**Outline Planning Application, Ribble Valley District  
3/11/1064 Primrose Mill (second phase) and Woone Lane, Clitheroe**

I refer to the amended plans for the junction of Whalley Road and Primrose Road, Clitheroe submitted on 31 May 2012 as part of the detailed drawings in support of the above outline application.

AMENDED PLANS RECEIVED
 DATE 17 MAY 2012

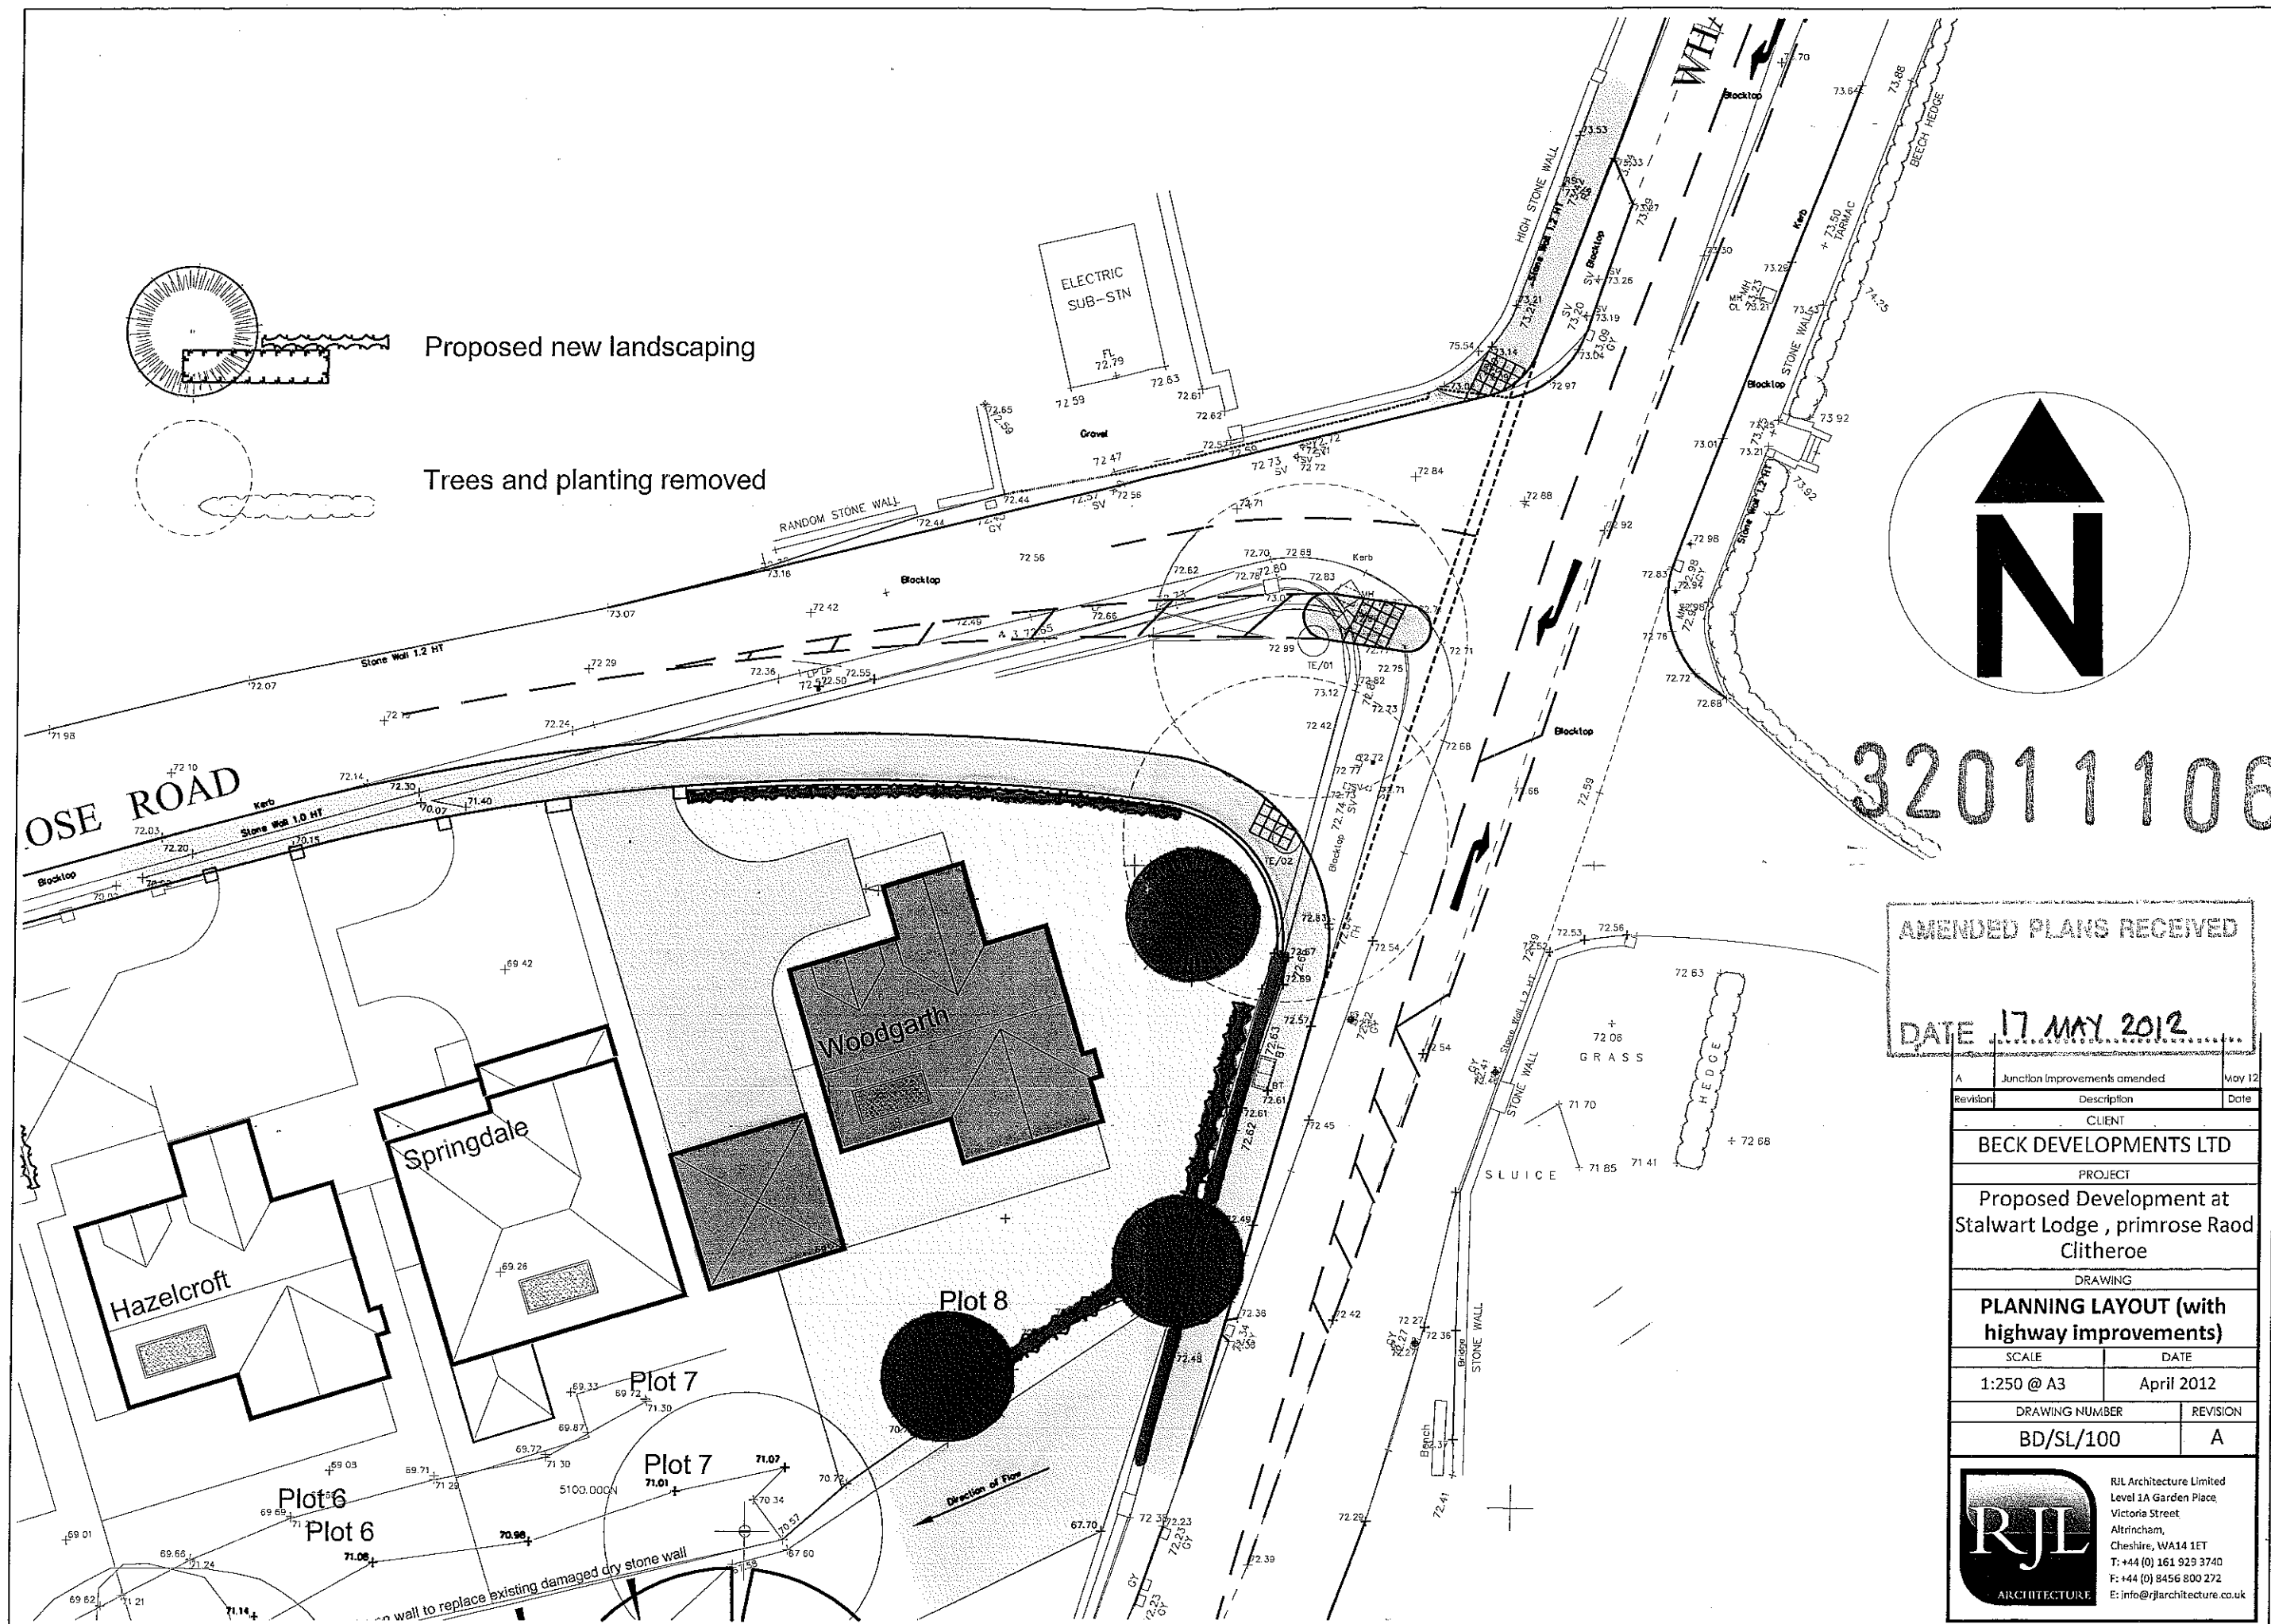
Further to my previous comments concerning the proposed highway improvements at this junction, Drawing No – N01952/08 RevB, provides a suitable design within the existing carriageway width, incorporating 2 x 3.1m running lanes and a 2.5m right turn lane.

I am satisfied that this arrangement complies with basic design principles, as set out in the Design Manual for Roads and Bridges, Volume 6 (most recently updated November 2011).

On this basis, I recommend this layout and have no further objections to the proposed application as it establishes a junction layout that corresponds to the essential highway design criteria for a right-turn ghost-island.
